**Transport
for NSW**

**Exhibition of Modification to Concept Plan MP 09_0099 MOD 4 and State
Significant Development Application (SSD 6962), 60 Wallgrove Road, Eastern
Creek**

CD15/14158

Figure 17: Signalised Site Access/Wallgrove Road Intersection Design Arrangement

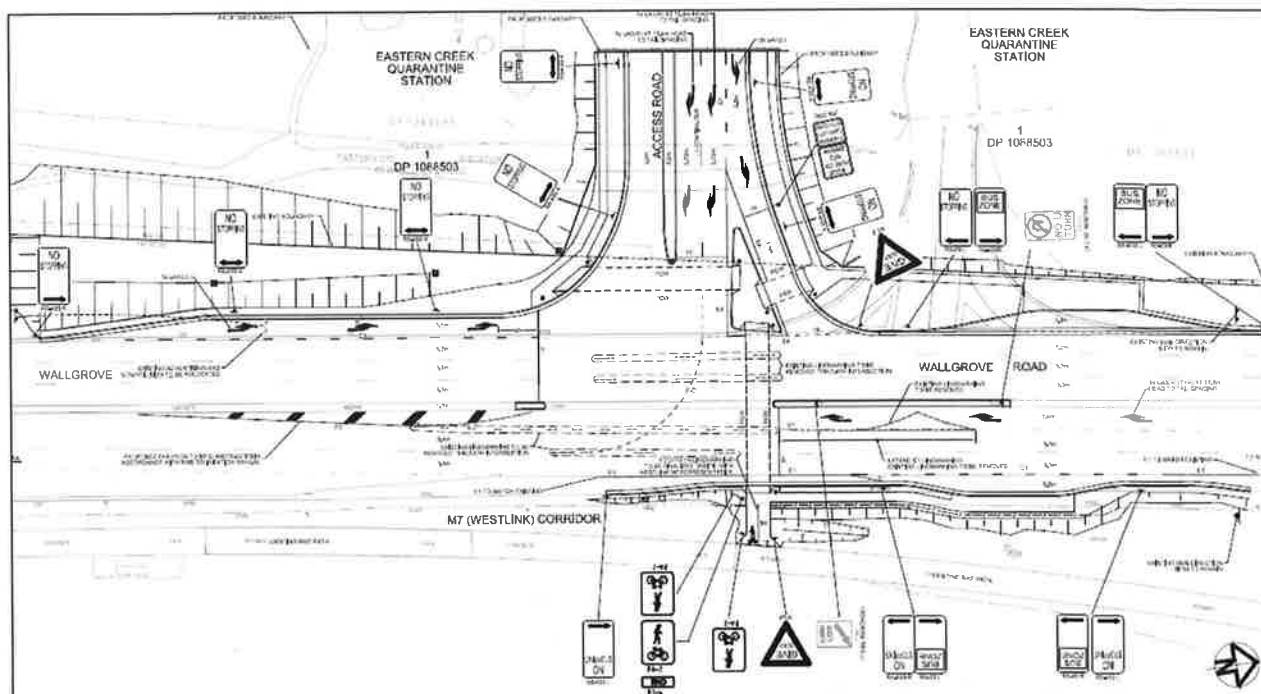
The proposed development site is strategically located adjacent to the Sydney Motorway network. Subject to future government policy on HPV routes, future tenants would be able to take advantage of the productivity benefits that High Productivity Vehicles offer. Therefore, it would be prudent to adopt a PBS Level 2B (i.e. up to 30m in length) vehicle turning path to design the site access and internal circulation roads at this stage to avoid changes to access arrangements in the future.
